Application No: AW/35/22/HH
Site Address: 49 The Drive Aldwick PO21 4DS
Description of works: Erection of single storey rear extension and conversion of loft to habitable use following the demolition of existing rear conservatory.

Thank you for your internet representation made on 3rd March 2022 which has been recorded as an objection with the comments as follows:

4 North (Rear) Elevation Proposed
1 : 100

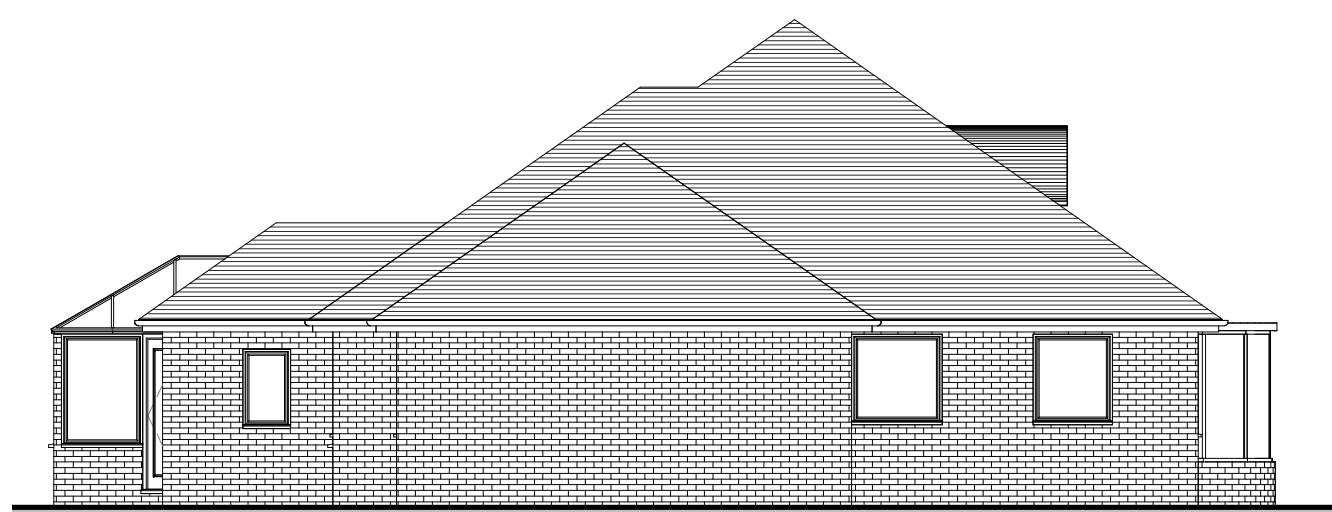
We have concerns about the amount of glass with the north rear elevation & possible loss of privacy to ourselves, as the proposed extension will also be closer to the fence between our properties.
